Our Ref: LU/401/17/HH

**Town & Country Planning Act 1990 (as amended)
Town & country Planning (Development Management Procedure) (England) Order 2015
Application for Householder Planning Permission**

Development Workshop/garage in rear garden.
Location 44 Sandfield Avenue Littlehampton

PLAN

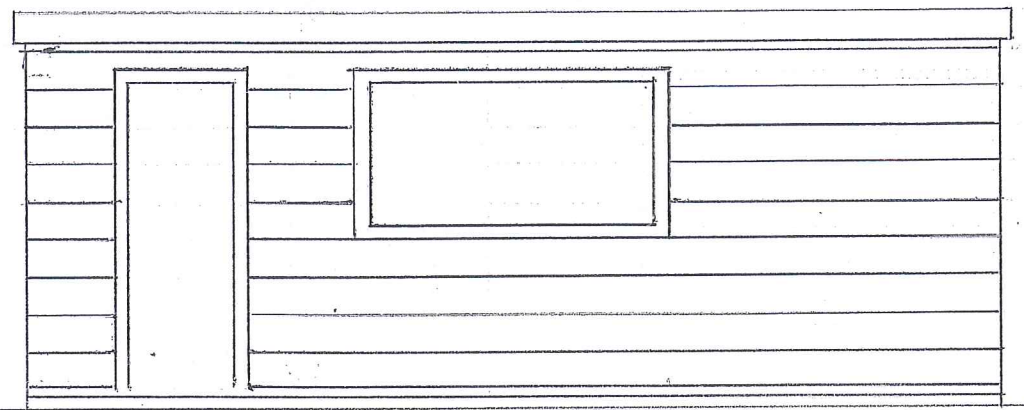
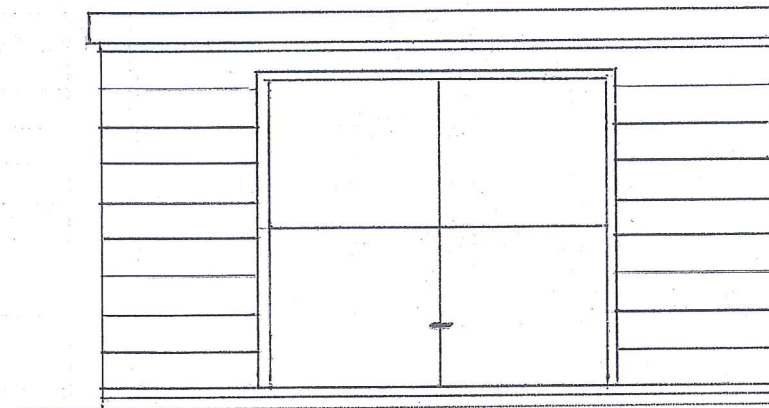
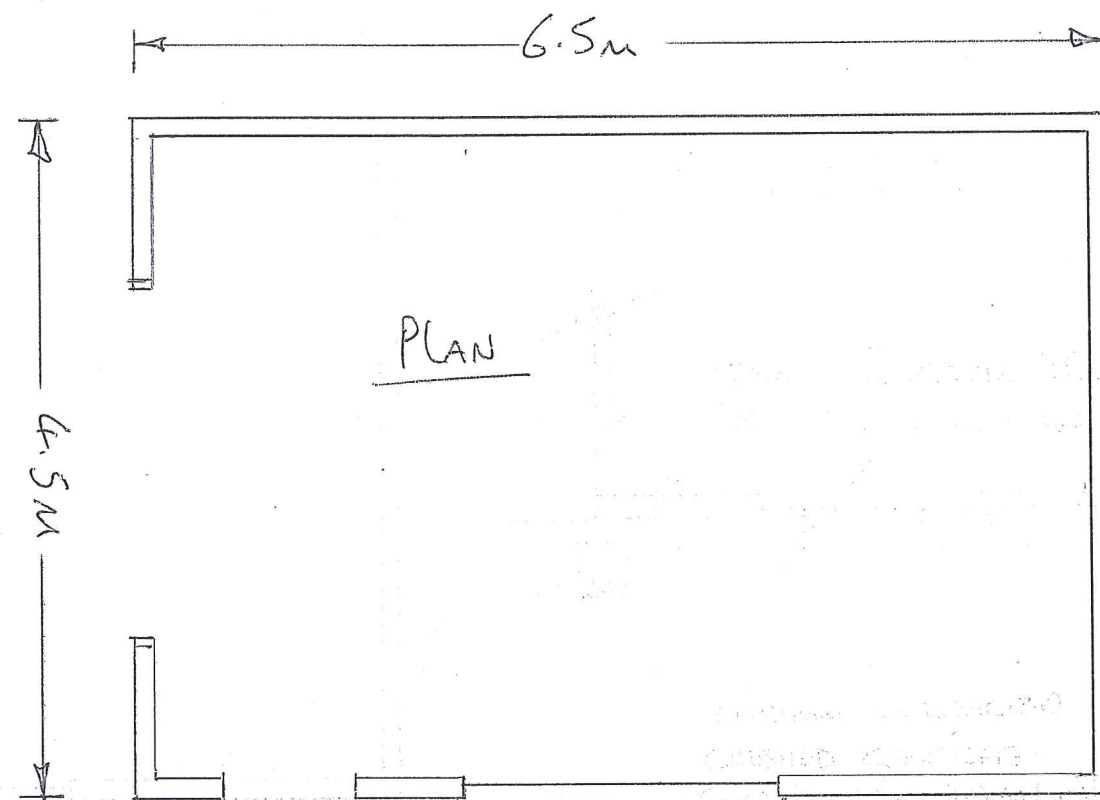
The proposed floor plan and elevations do not accord. Please show all windows and doors on the floor plan that are shown on the proposed elevations. Please ensure the proposed floor plan and elevations scale correctly.
